Recommendation Report for Lawful Development Certificate for a Proposed Use or Development

REF NO: LU/339/21/CLP

LOCATION: Southdown Nursery, The Bungalow
Old Mead Road
Littlehampton
BN17 7PU

PROPOSAL: Lawful development certificate for a proposed new detached outbuilding

REV	DESCRIPTION	DATE
1	PROJECT SOUTHDOWN NURSERY OLD MEAD ROAD LYMINSTER WEST SUSSEX	
2	DRAWING TITLE PROPOSED OUTBUILDING - GENERAL PROPOSALS	
3	SCALE 1:100@A3	DRAWN BY FLB
4	DWG NO 1093/01	DATE OCT 21
5		REV. -

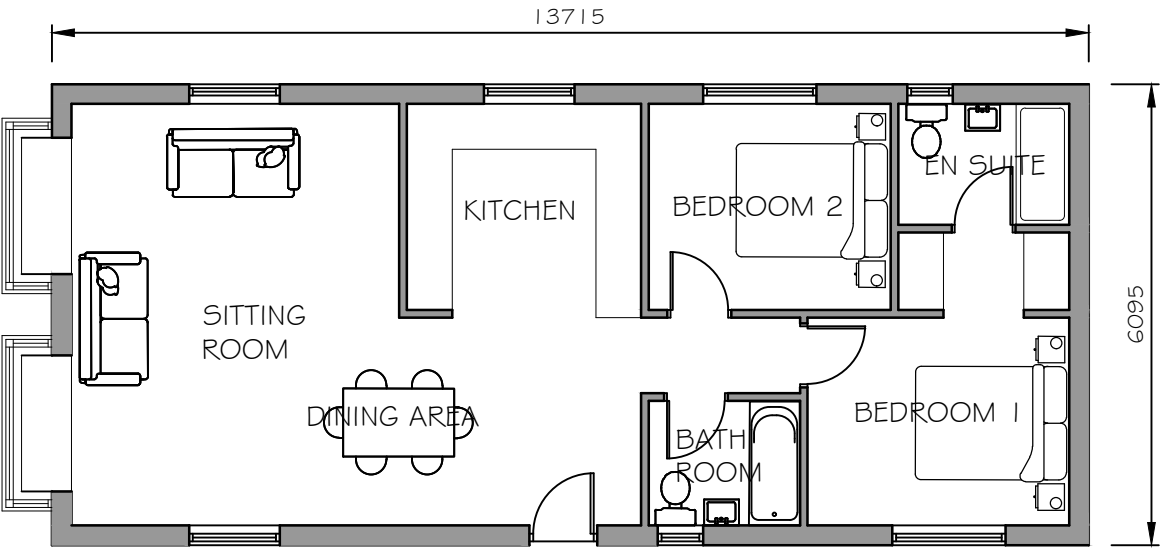
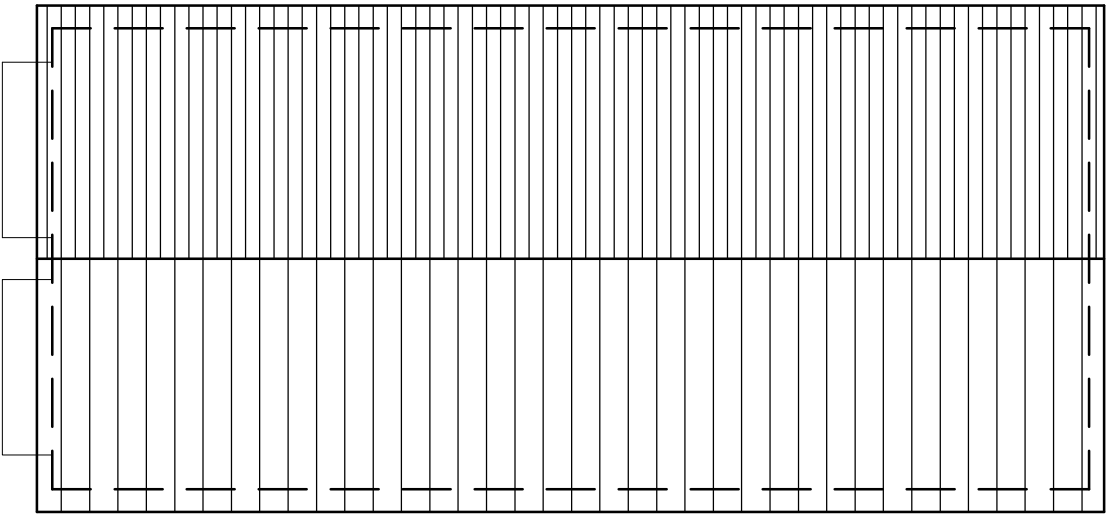
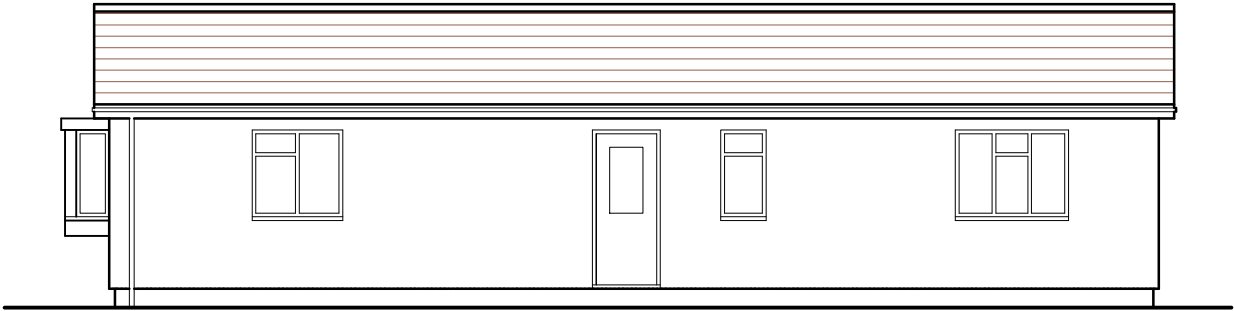
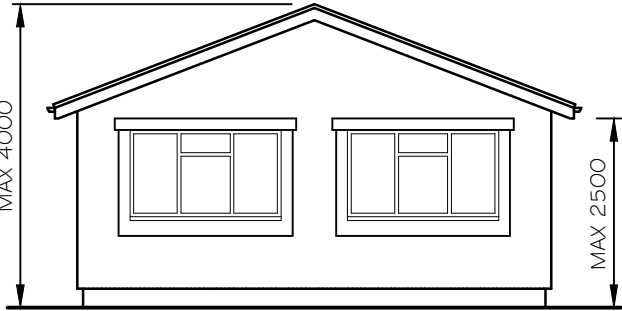
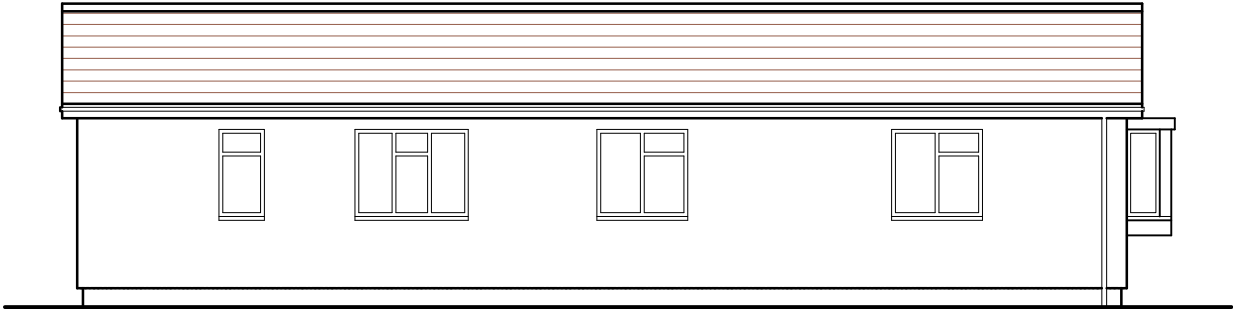
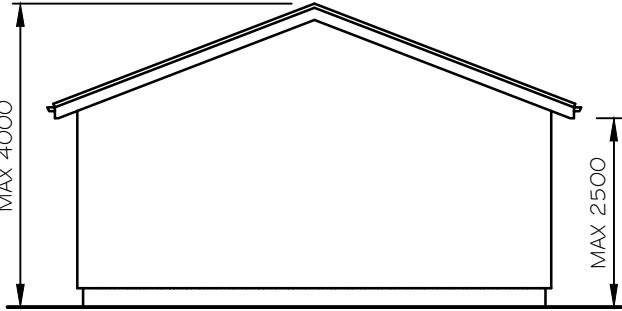
The proposed outbuilding would consist of 2 bedrooms, 1 with en-suite, a kitchen, living area with 2x bay windows and dining room and further bathroom. Its overall gross internal floor area would be 72.05 square meters.

A residential annex or outbuilding would normally be described as primary accommodation. The outbuilding which is subject of this application would include 2x bedrooms, living, dining and kitchen space so that it could function as an independent unit. I do not consider this building to be incidental to the enjoyment of the main dwelling house.

The proposed outbuilding conflicts with relevant sections E.4, nor is land believed to be within the residential curtilage of the dwellinghouse and it is not considered permitted development and as such does require the submission of an application for full planning permission.

DRAWING TITLE
PROPOSED OUTBUILDING - SITE
LOCATION PLAN AND BLOCK PLAN

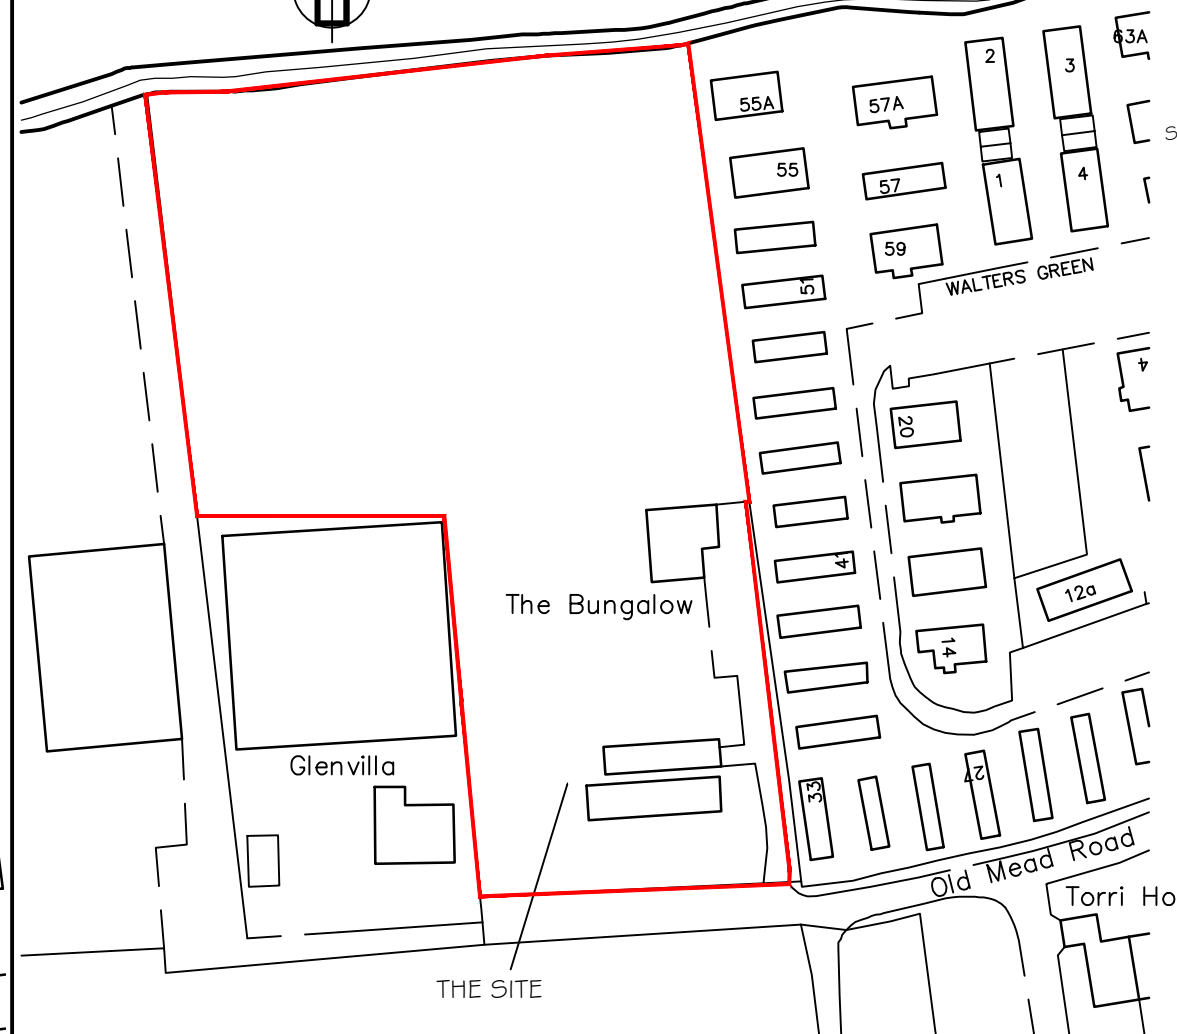
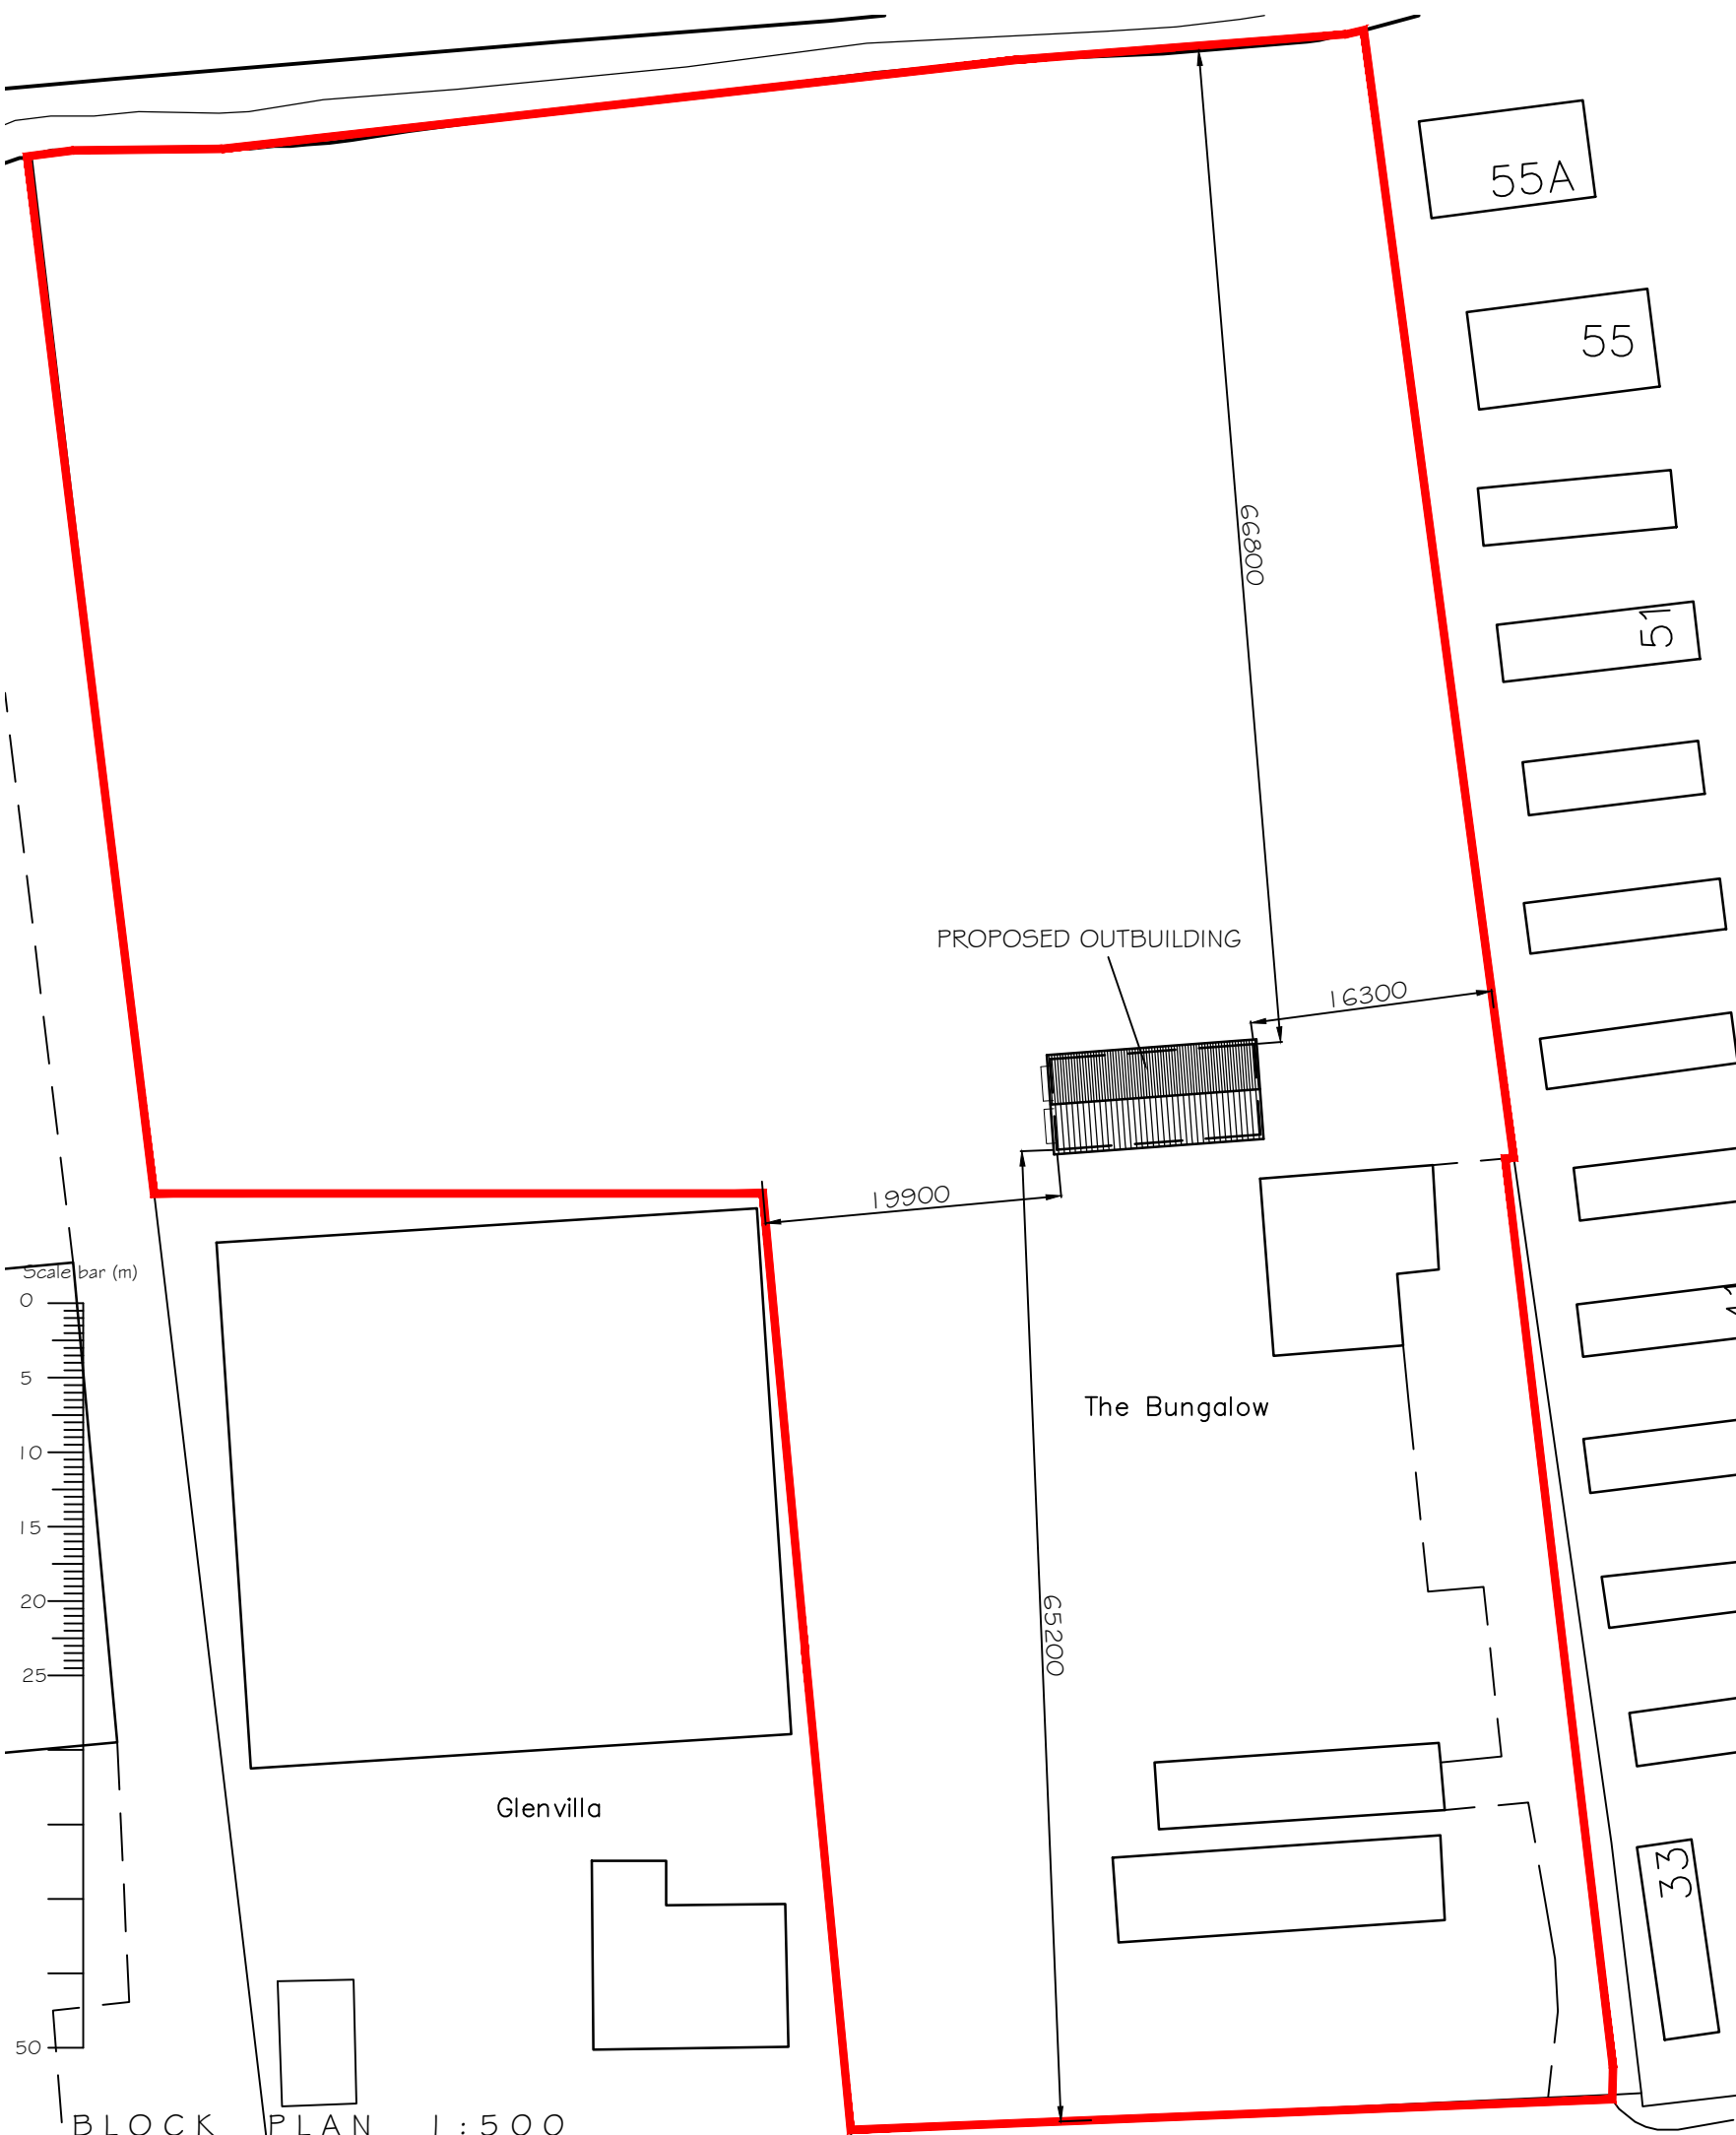
The outbuilding would be situated to the north of the bungalow. The land adjacent to the northern elevation of the bungalow which appears to have been utilised for agricultural purposes until at least 2016, and was sectioned off with a fence and hedgerow boundary. No evidence has been supplied stating that the land to the north of the bungalow is now part of the residential curtilage and as such on the balance of probability this land fall outside of the residential curtilage of the dwellinghouse and is not afforded Permitted development Rights under Schedule 2 part 1 of the GPDO.
